ADDENDUM #3 Dated August 9, 2004

East End Elementary School  
Portland, Maine

City of Portland BID # 8704

STEPHEN BLATT ARCHITECTS  
P.O. BOX 583  
10 DANFORTH STREET  
PORTLAND, ME 04112-0583

230+00  
231+00  
OFFSITE STORM DRAIN PROFILE NS-D  
SCALE: 1"=30' HORIZ., 1"=3' VERT.

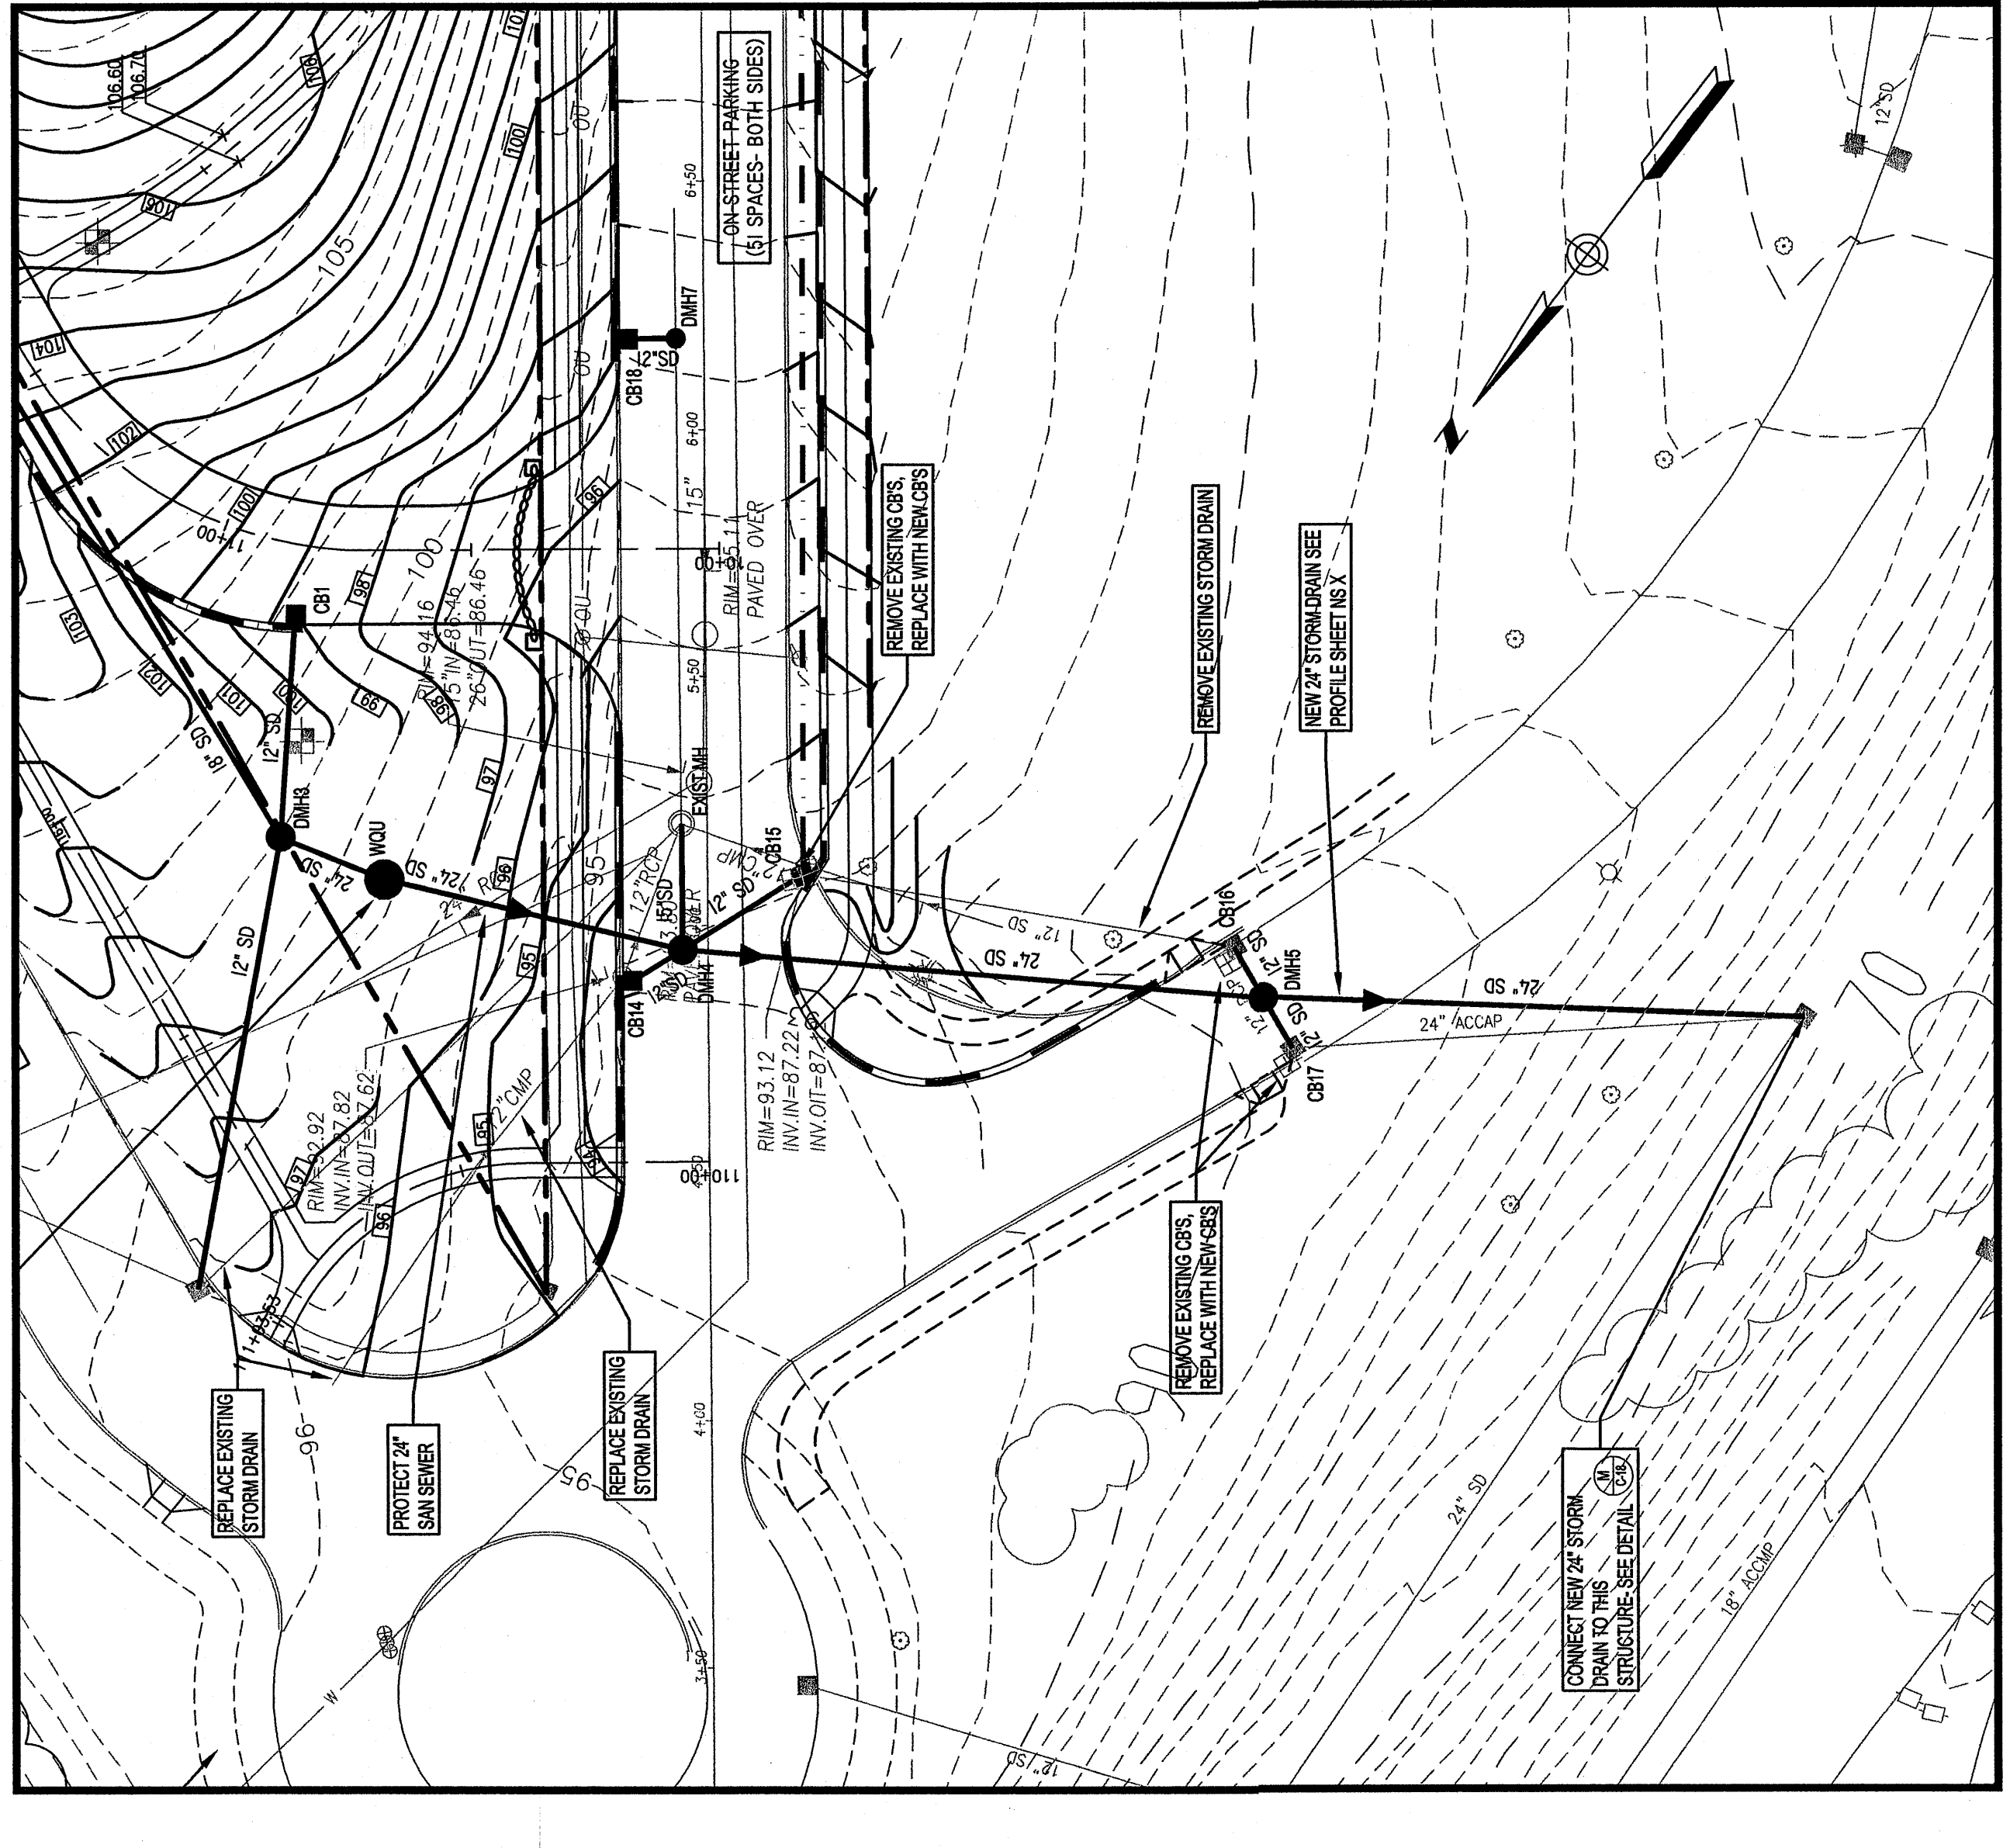
A potential bidder inquired about the size of inlets. The profiles identify the size of the inlets, catch basins, and manholes.
